CITY OF ALBUQUERQUE

January 17, 2014

**Re: The 14 East
Grading and Drainage Plan
Engineer's Stamp Date 1-15-2014 (K13/D050)**

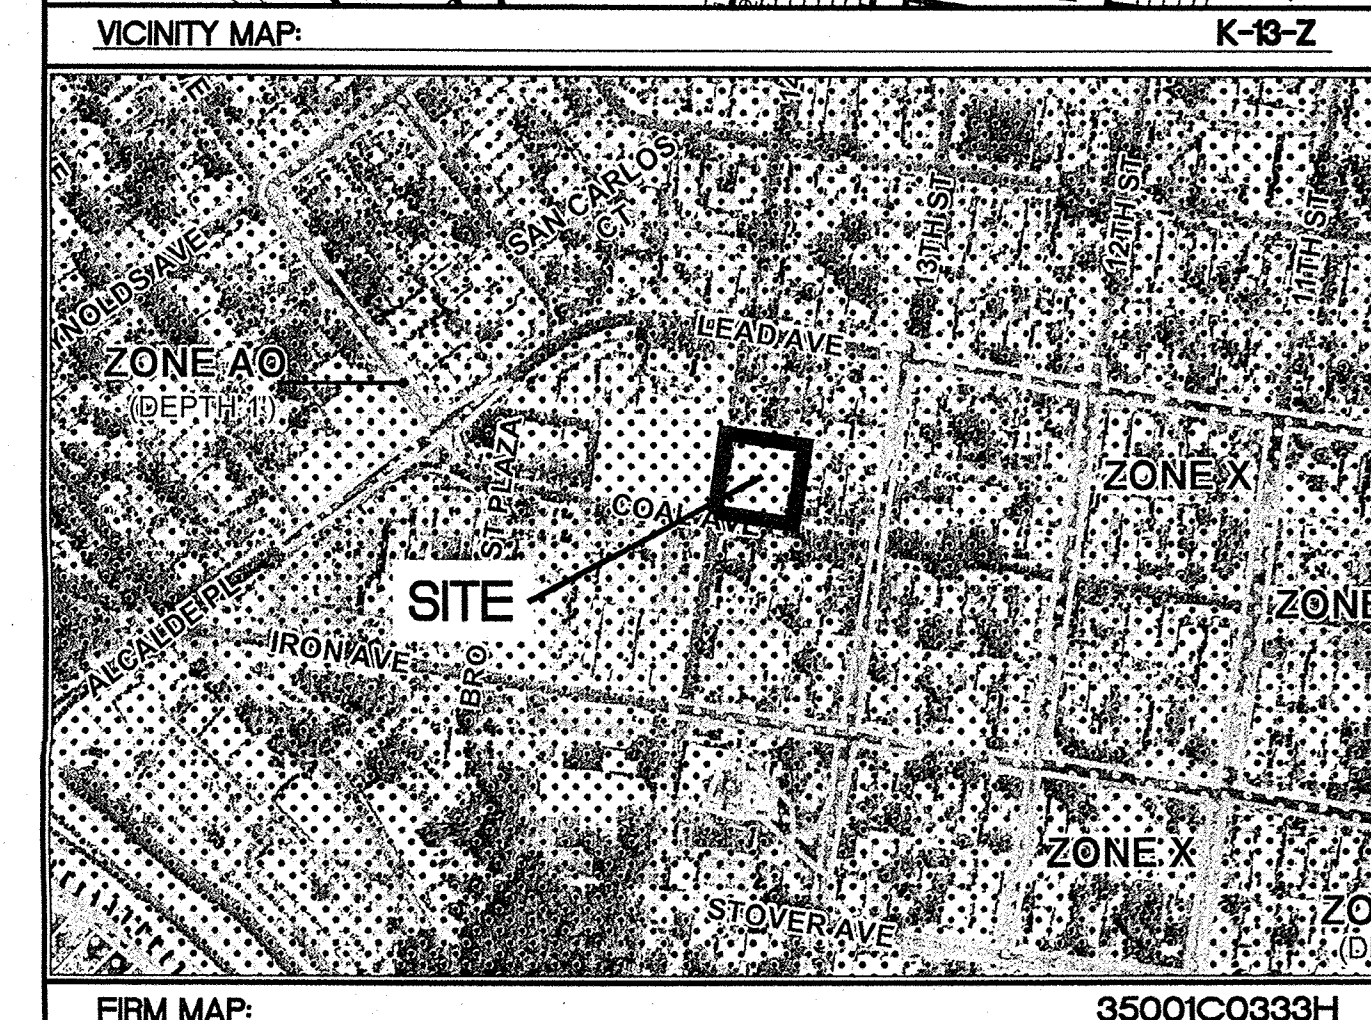
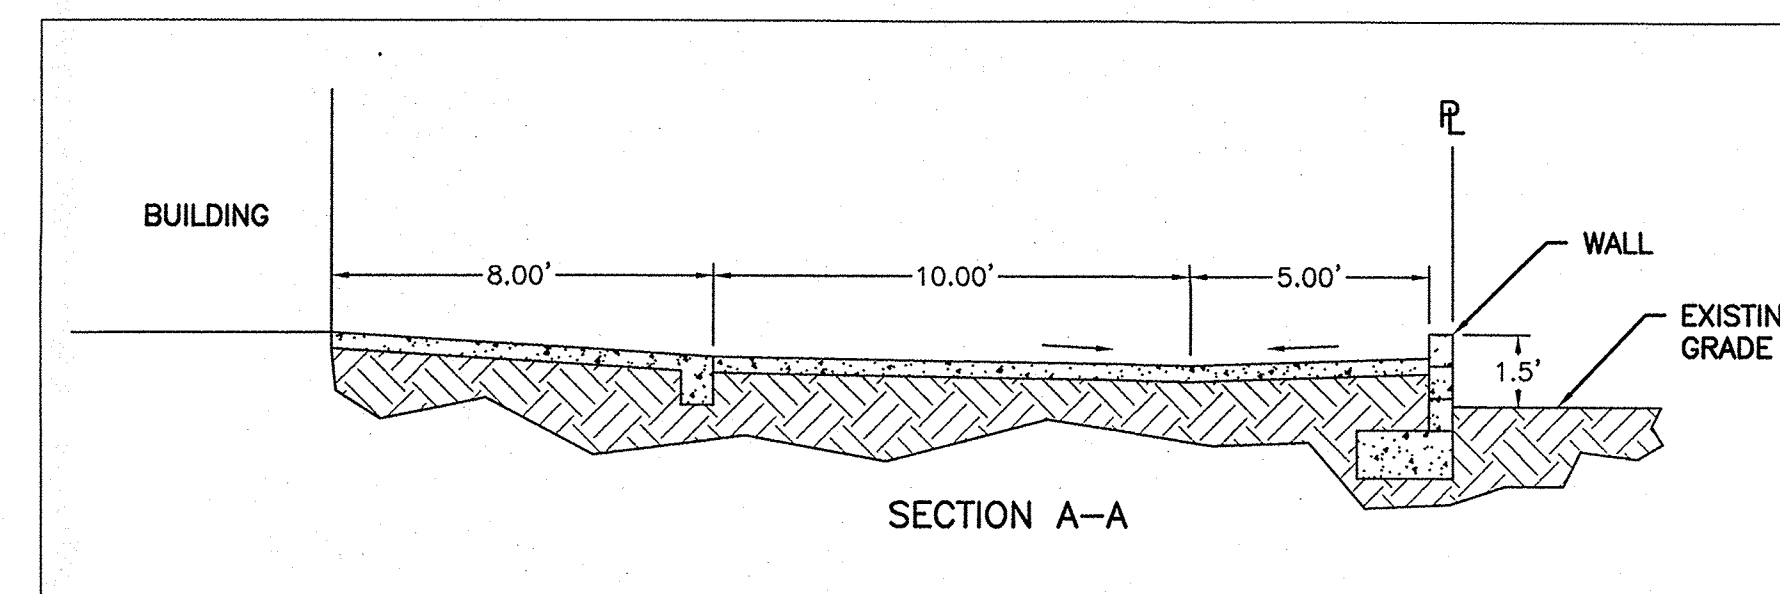
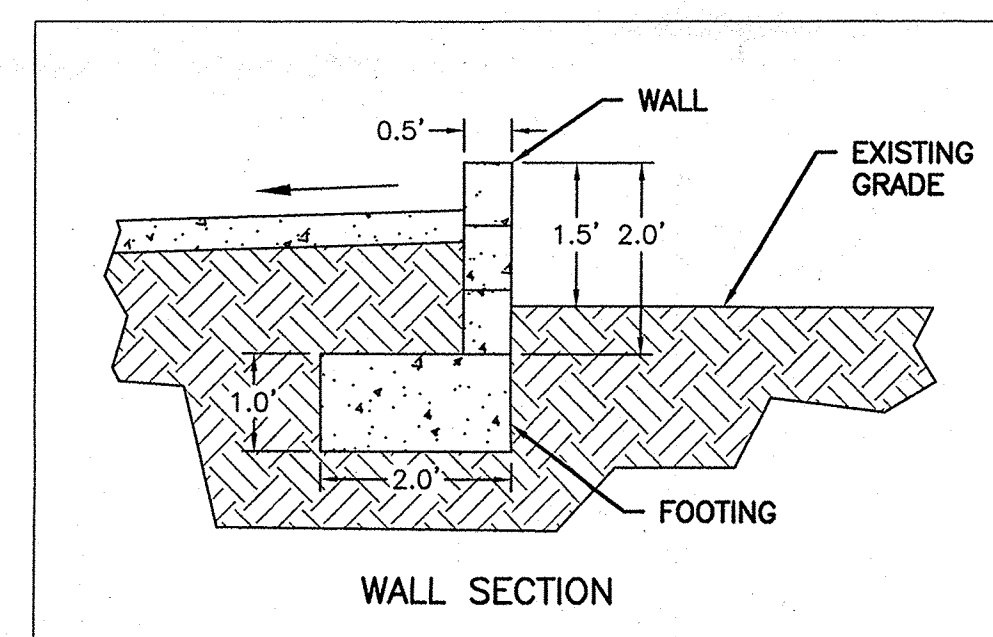
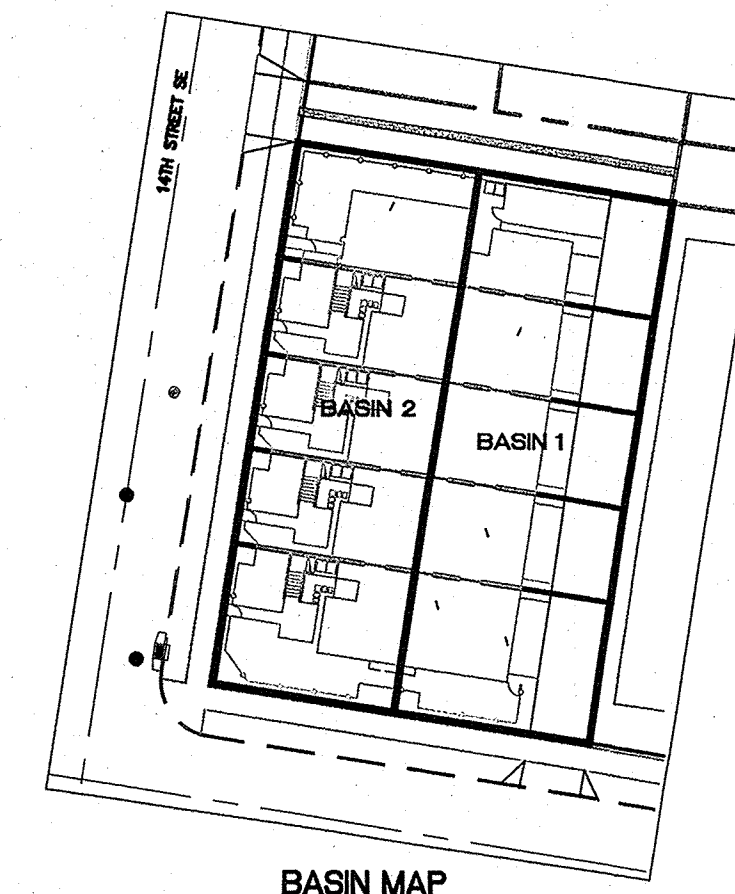
- Show more spot elevations along the alley to assure the runoff and gates/entrances are not being blocked with the proposed alley improvements. Show all the existing improvements.
